Redevelopment of land at the former Rising Sun PH and the construction of 7no. new dwellings with associated landscaping and parking.

Land adjacent to The Rising Sun 351 Chichester Road Bognor Regis

Thank you for your internet representation made on 9th February 2013 which has been recorded as '**an objection**' with the comments as follows:

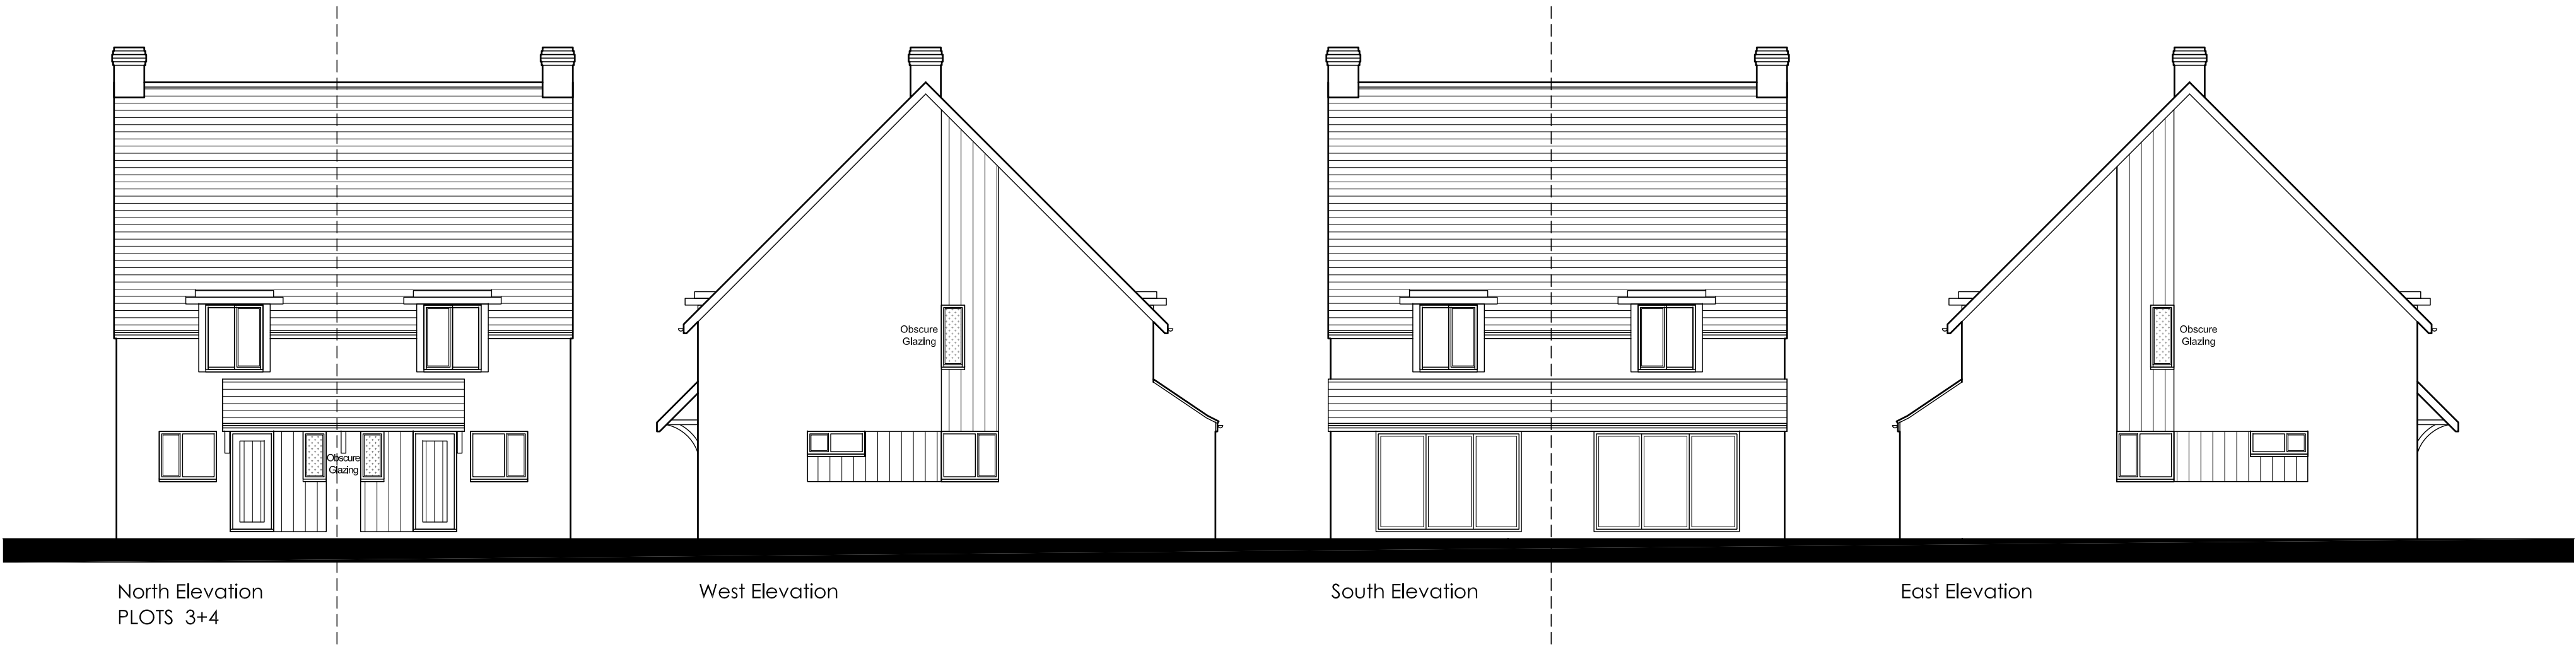
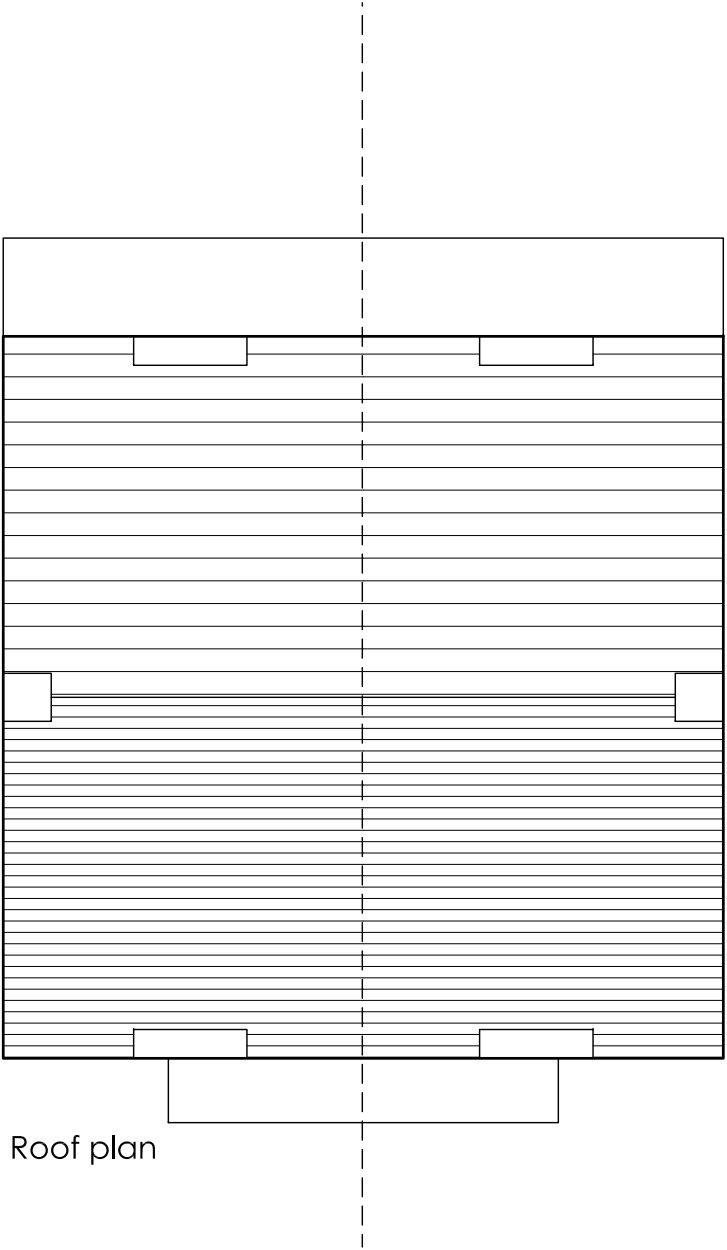
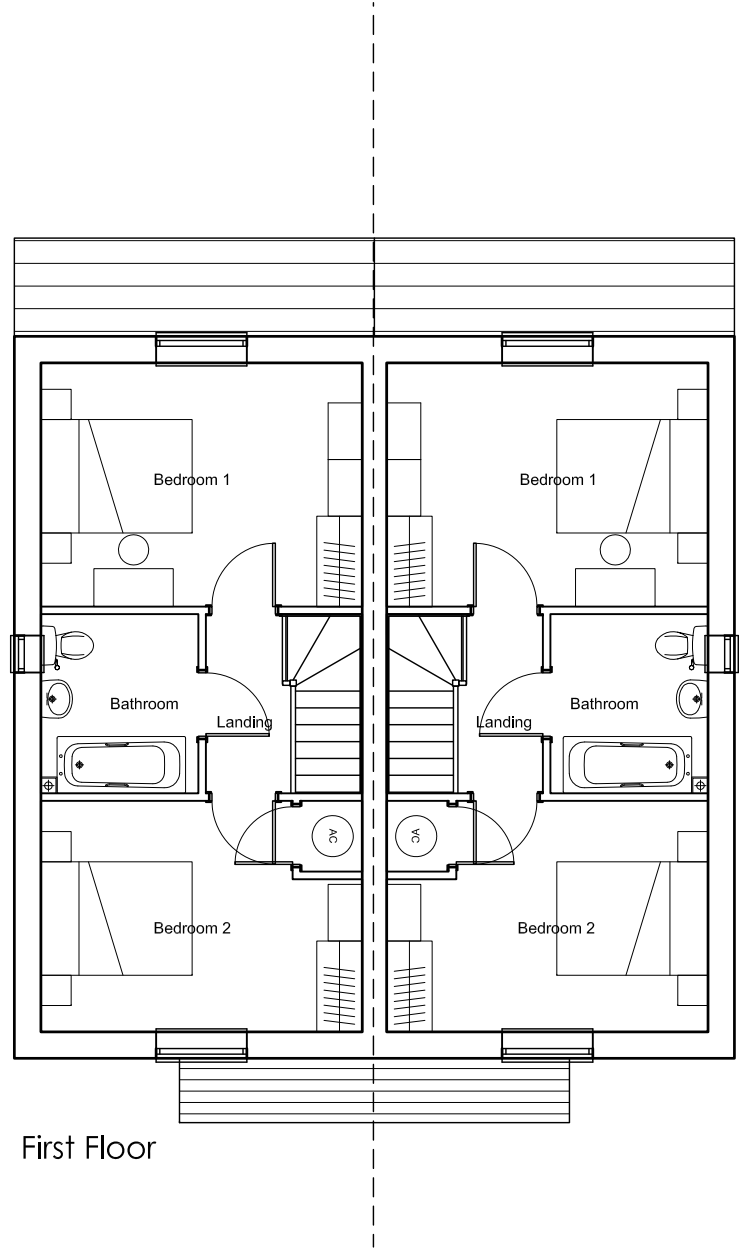
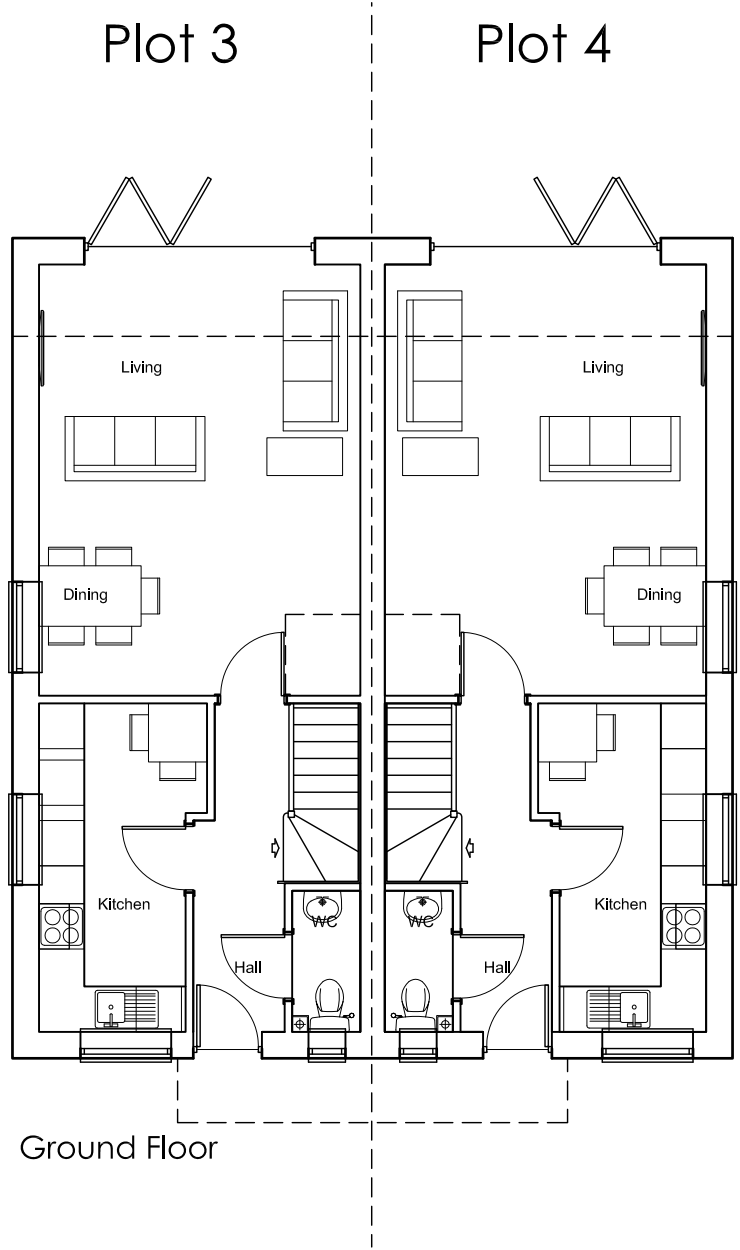
*I object that houses no 1 and 2 have three storeys with dormer windows. These will look directly into my garden and house. Most other houses in this area are only 2 storey without the dormer windows which gives residents more privacy.*
